Your Ref: OWPC19838
Our Ref: BE/84/18/HH 17-07-2018
Please ask for:
Amber Willard

Rear conservatory
6 Violet Close Bersted

PROPOSED CONSERVATORY

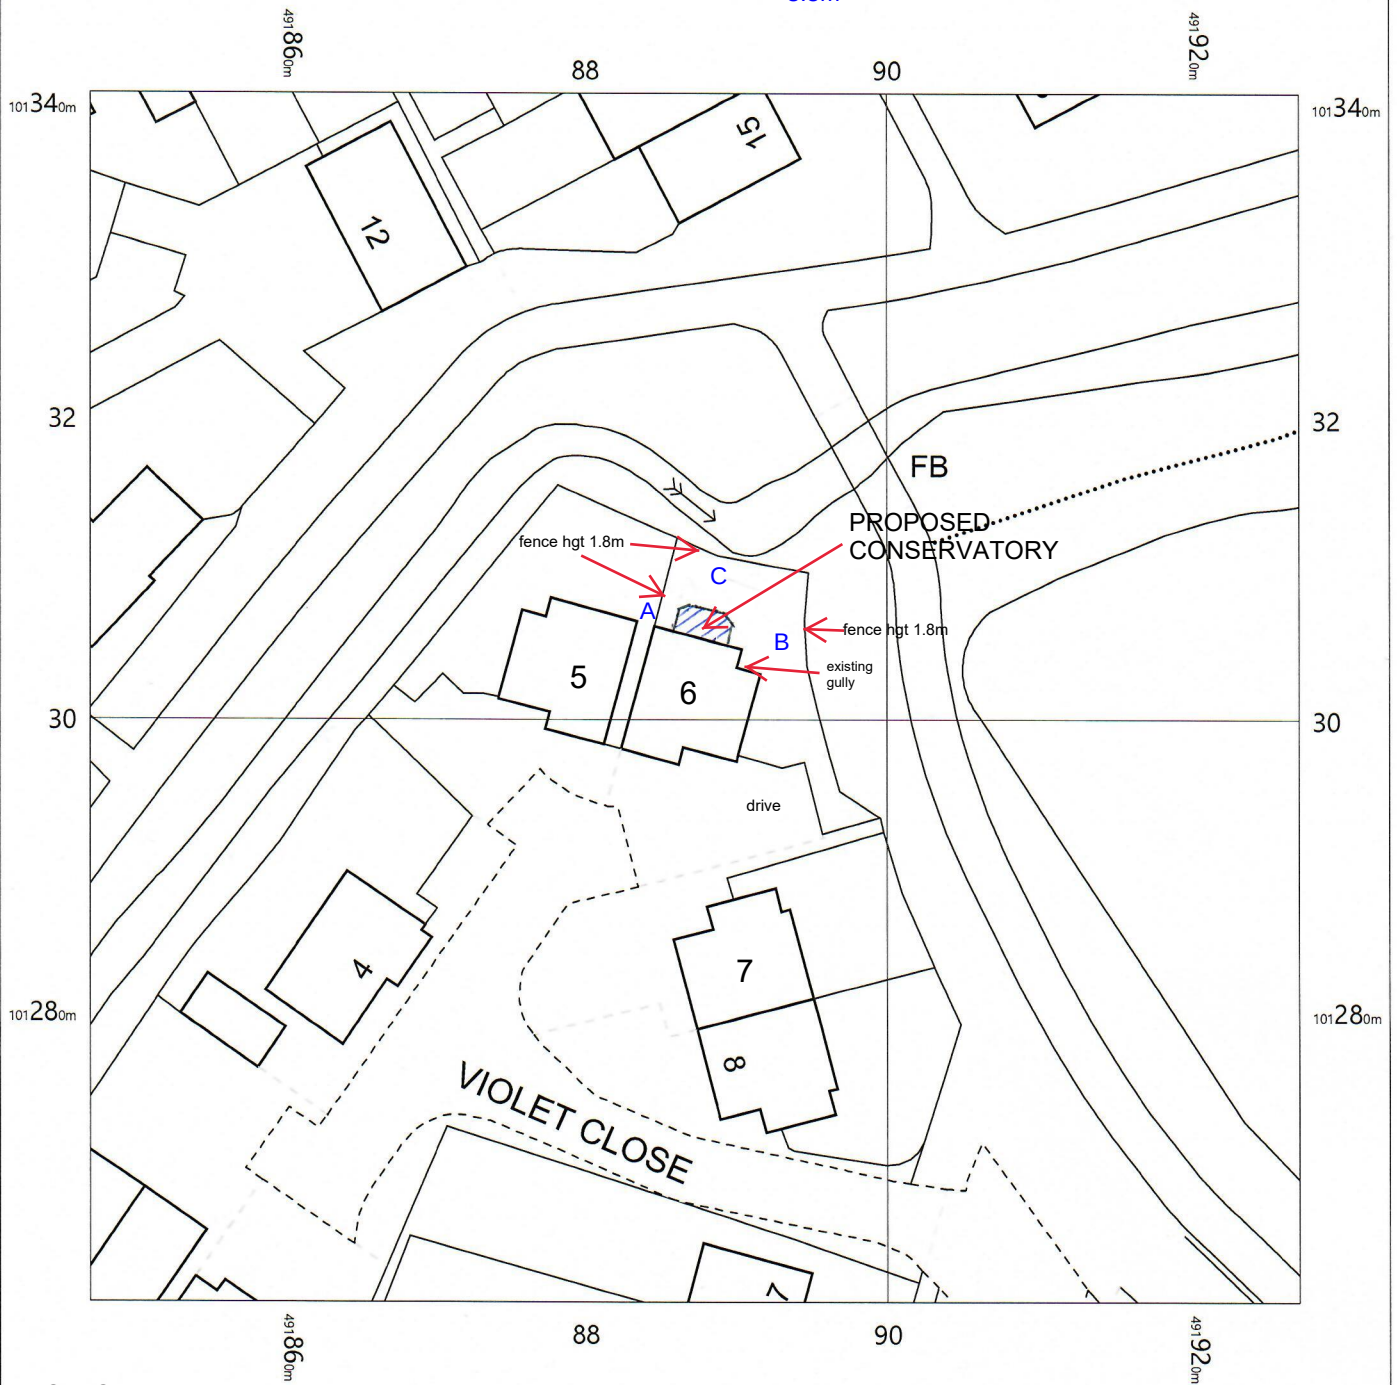
We object to this planning application as the plans demonstrate that we will lose half of the views from our garden of the protected trees and the skyline, and lose most of the morning sunlight that we get on our patio. The proposed development reaches half way along our fence and the height will mean all we can see is the roof of the proposed development.
